PPR2621

**FINAL DRAINAGE REPORT  
ADDENDUM NO. 2**

**MONUMENT ACADEMY TRACK AND FIELD  
LOT 1, MONUMENT ACADEMY SUBDIVISION**

JPS Project No. 040201  
PCD File Nos. EGP-261 / PPR-19-009

DEVELOPED
DRAINAGE PLAN

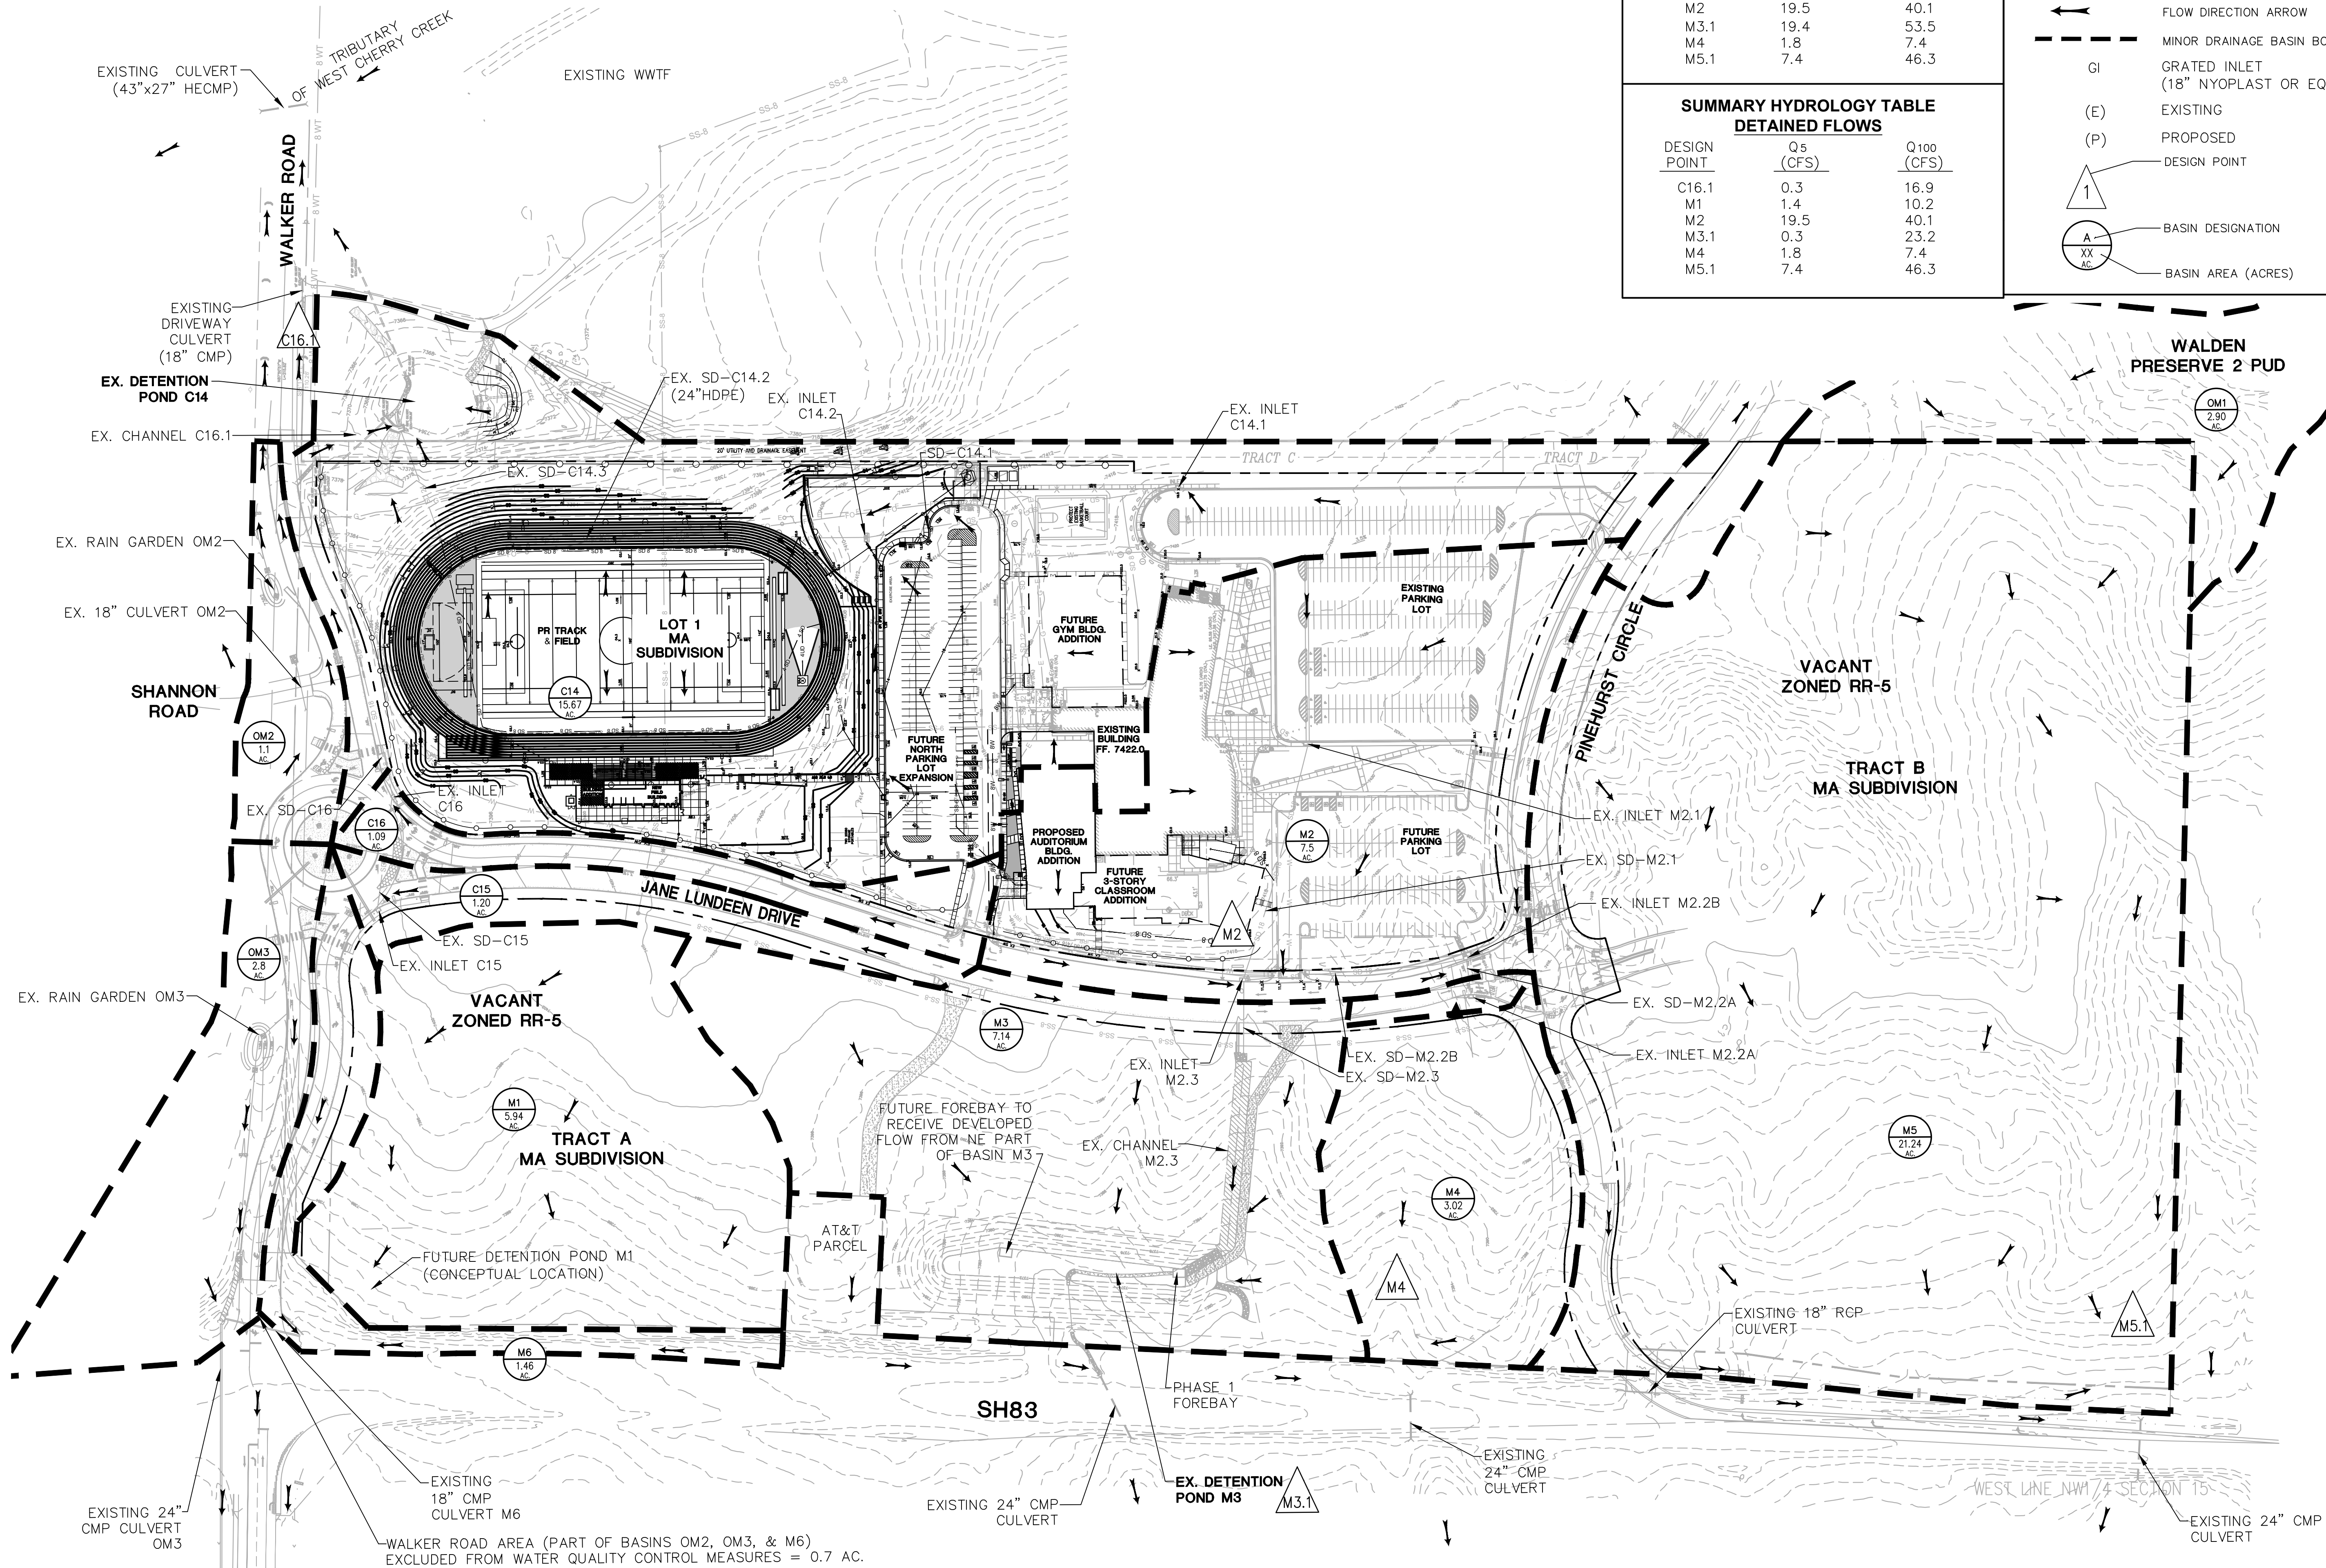
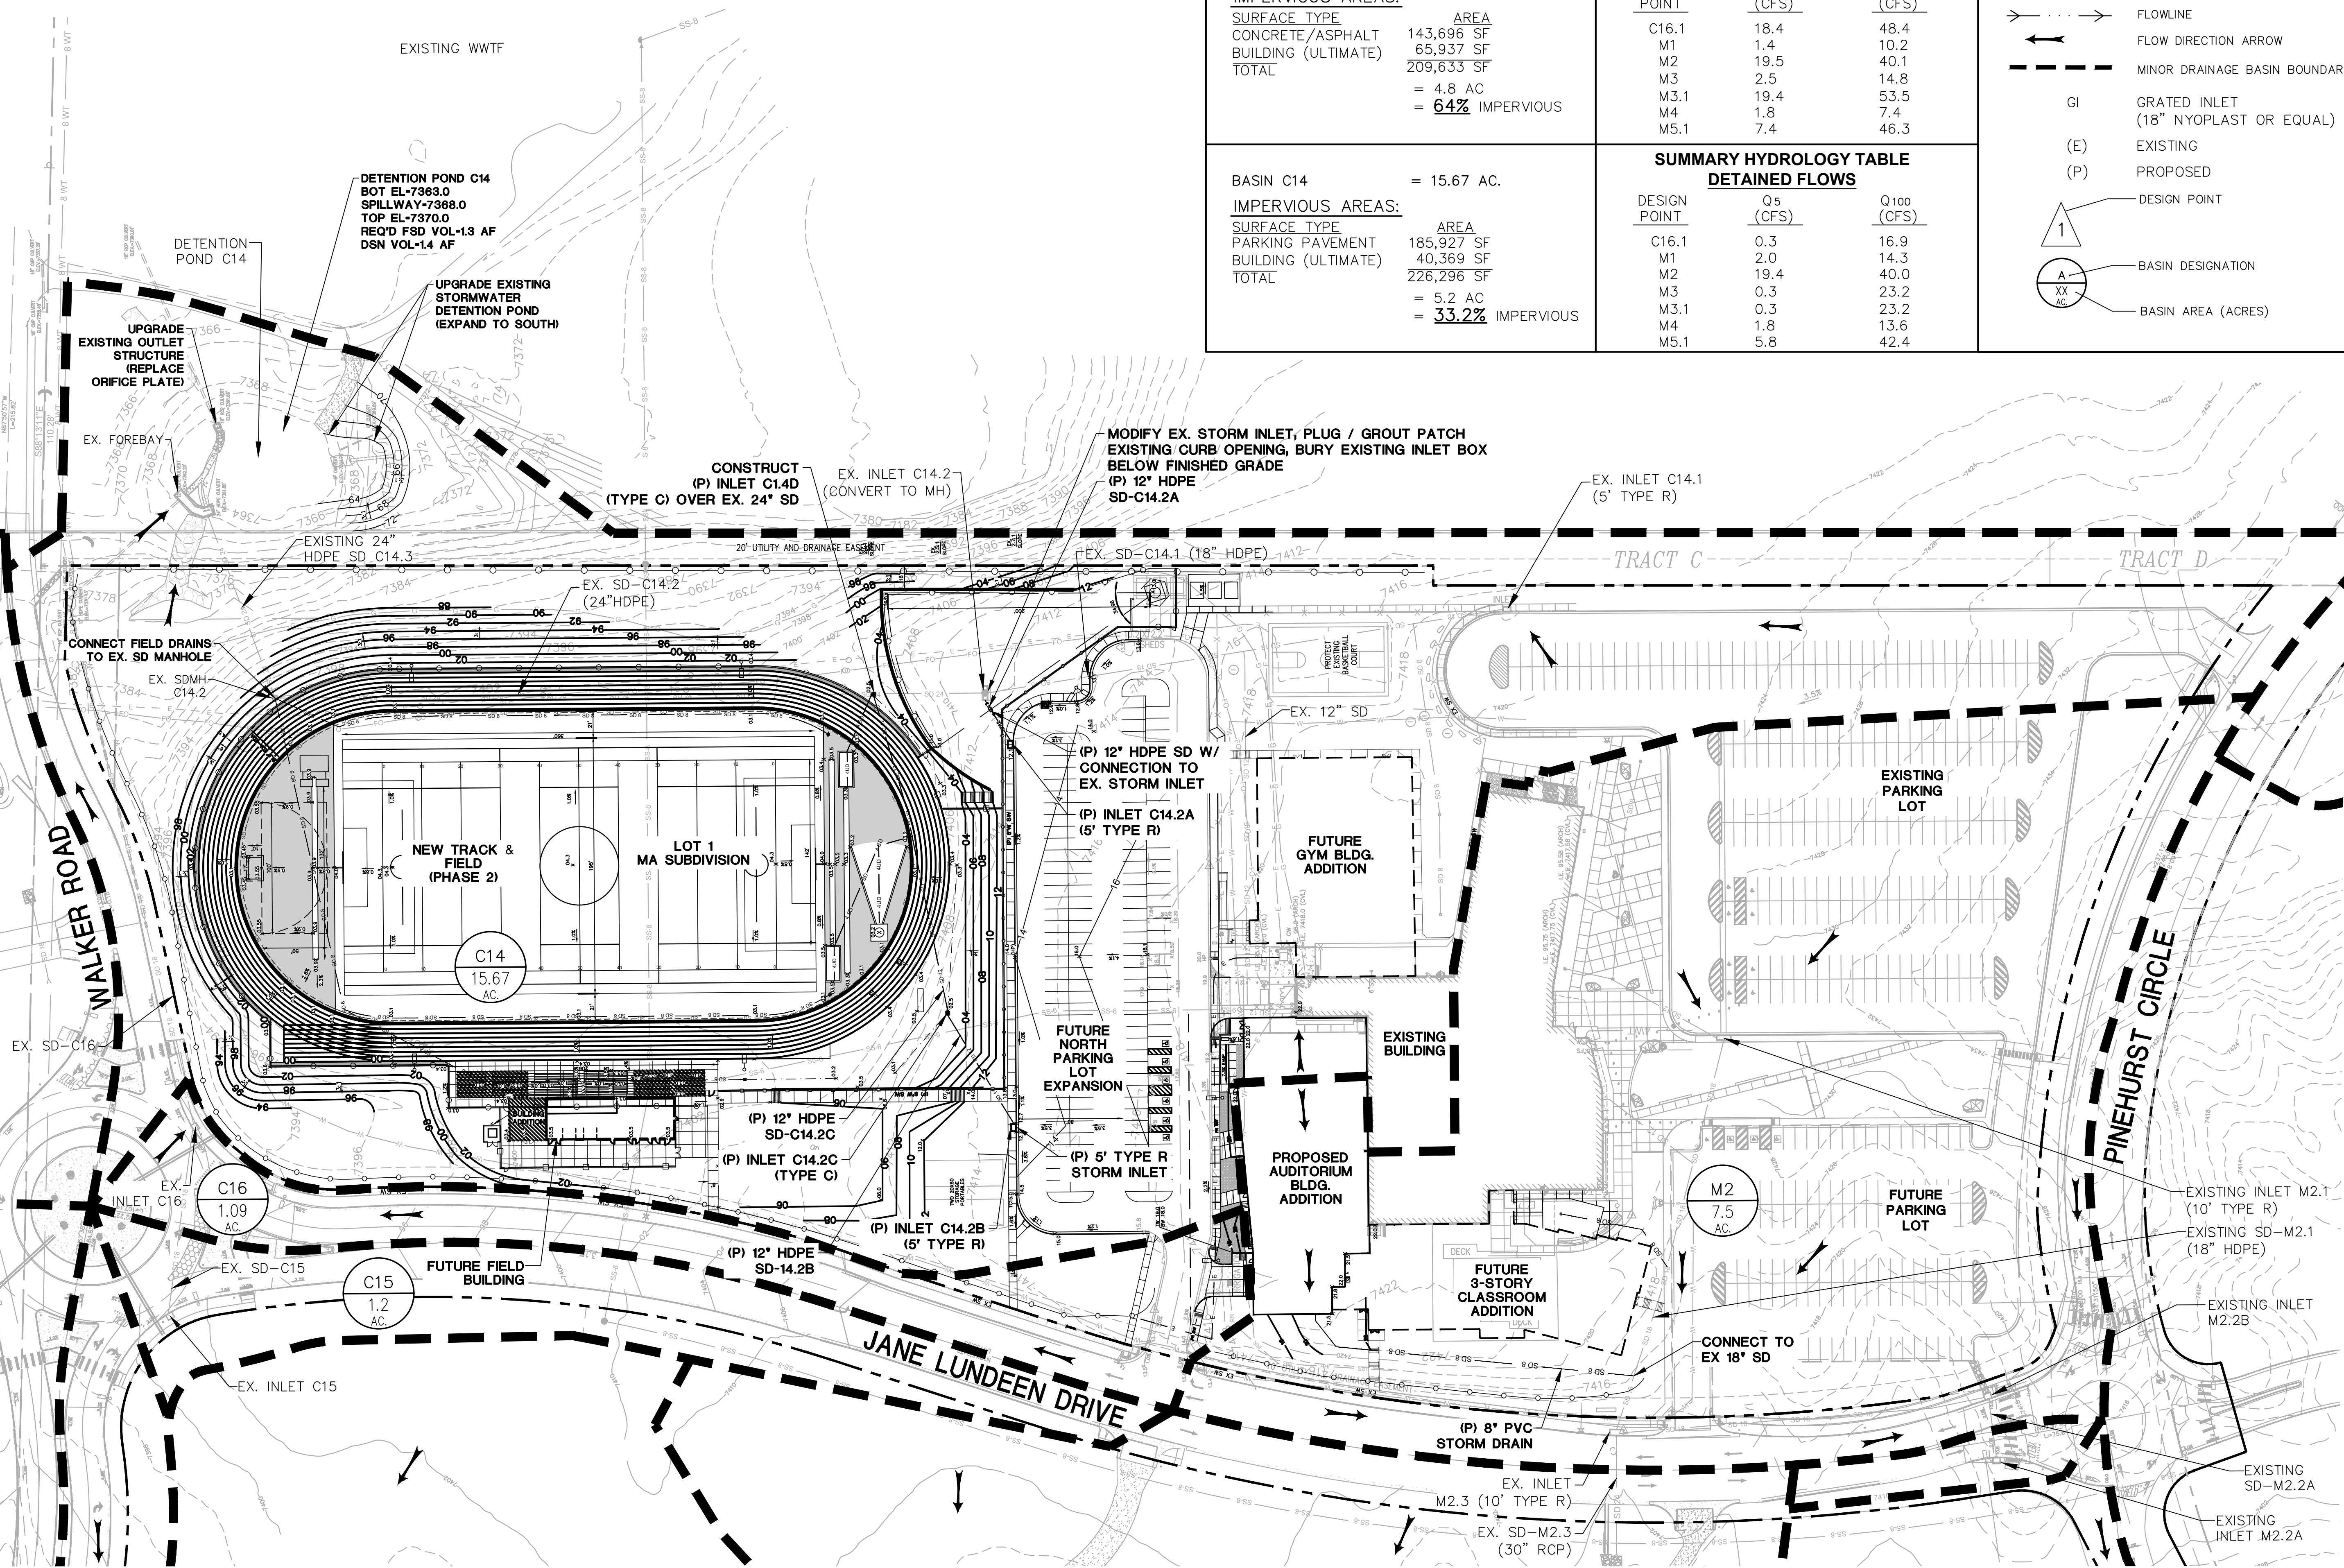
It appears that the northern parking lot is being constructed under this application. Please revise and include.

Because of the increase in flows is this existing system still adequate? See related comments in calculations and please address.

Please address the increase in flows coming from the proposed roof drains and whether the original drainage report, infrastructure, and pond accounted for these flows.

Comments made on the LOI and SDP regarding whether this parking lot is future or proposed under this application as the labeling shows future and the linetype makes it look like it is proposed under this application.
